18th April 2024
Our Ref: 24032

Re: Planning and Development Act, 2000 (as amended) and the Statutory Regulations thereunder. Third party submission by local residents in relation to Application under Section 37L of the Planning and Development Act 2000, as amended for quarrying and aggregate extraction on lands located at Redbog and Philipstown, Co. Kildare.

An Bord Pleanála Ref. no. QD09.319218

We, Marston Planning Consultancy, 23 Grange Park, Foxrock, Dublin 18, D18 T3Y4 are instructed by the Save Kildare Uplands Action Group, Harrington & Co Solicitors, Newtown, Bantry, Co. Cork, P75 EA03; to make a submission in regard to the above section 37L application lodged on behalf of Hudson Brothers Ltd. for quarrying and aggregate extraction on lands located at Redbog and Philipstown, Co. Kildare. As this is an application under section 37L of the Planning and Development Act, being made to An Bord Pleanála, no fee accompanies this submission. The members of the Group are listed to the rear of this submission in Appendix A.

Figure 2-3 - Operational Plan - Phase 1.

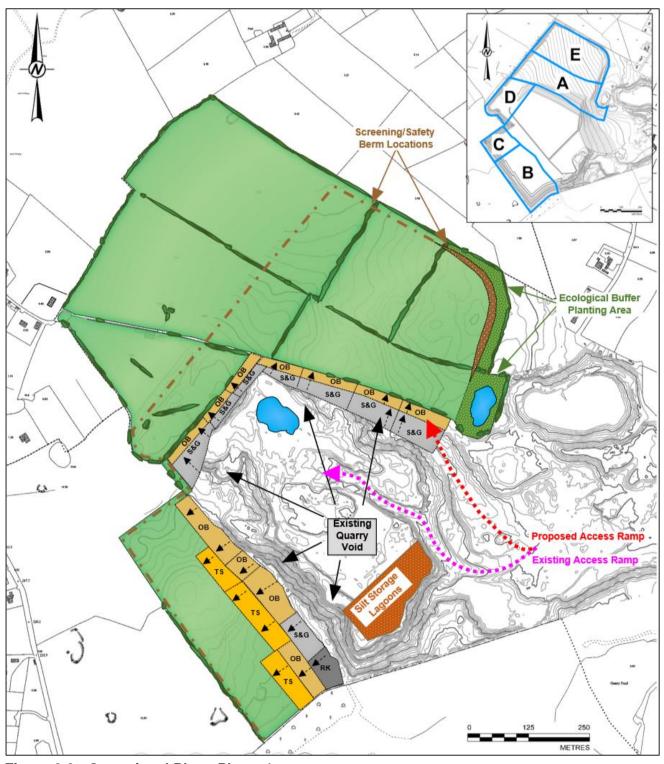
We note that the applicant claims that the proposed finished floor level for each phase of extraction will not take place below a level of 1m above the highest seasonal water table on site as permitted under Planning Ref. 07/267. As this permission has now ceased to be operational, we would severely question whether this remains a correct approach in this instance. The applicant state that the finished floor levels are therefore dependent on groundwater levels and how the ground water may fluctuate both seasonally and due to changes over the lifetime of the quarry.

Figure 2-6 - Operational Plan - Phase 4 - Restoration. Overview of main features. Please refer to Chapter 11 (Landscape and Visual) for detailed Restoration Plan.

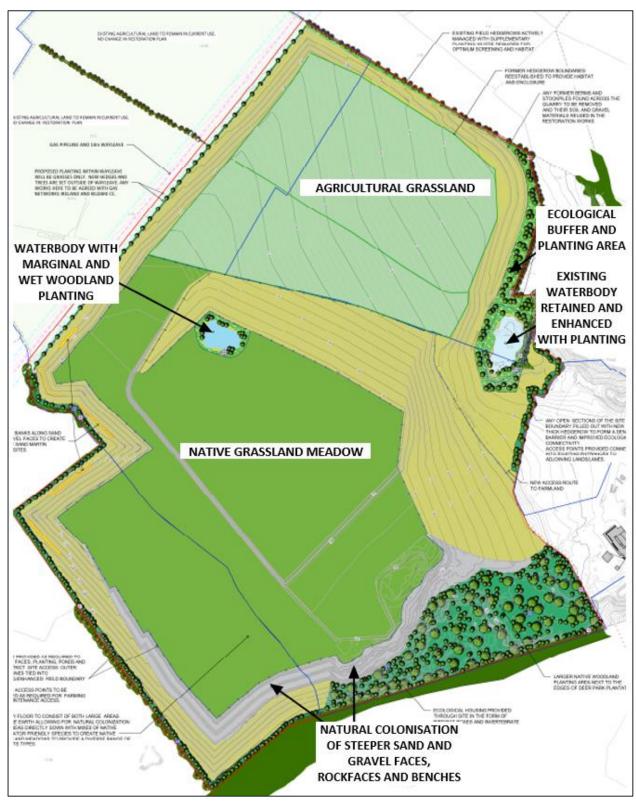
We note that the application is accompanied by a single drawing that indicates it as forming the restoration plan for the quarry. Very little additional information is provided beyond it being restored to a mixture of grassland, hedgerows, woodland and a waterbody. We submit that the restoration plan is at such a high level that it will hard to assess whether it has been implemented or not, irrespective of the other environmental impact concerns of our clients. The application states that all plant, equipment and temporary structures shall be decommissioned and removed from the Site.
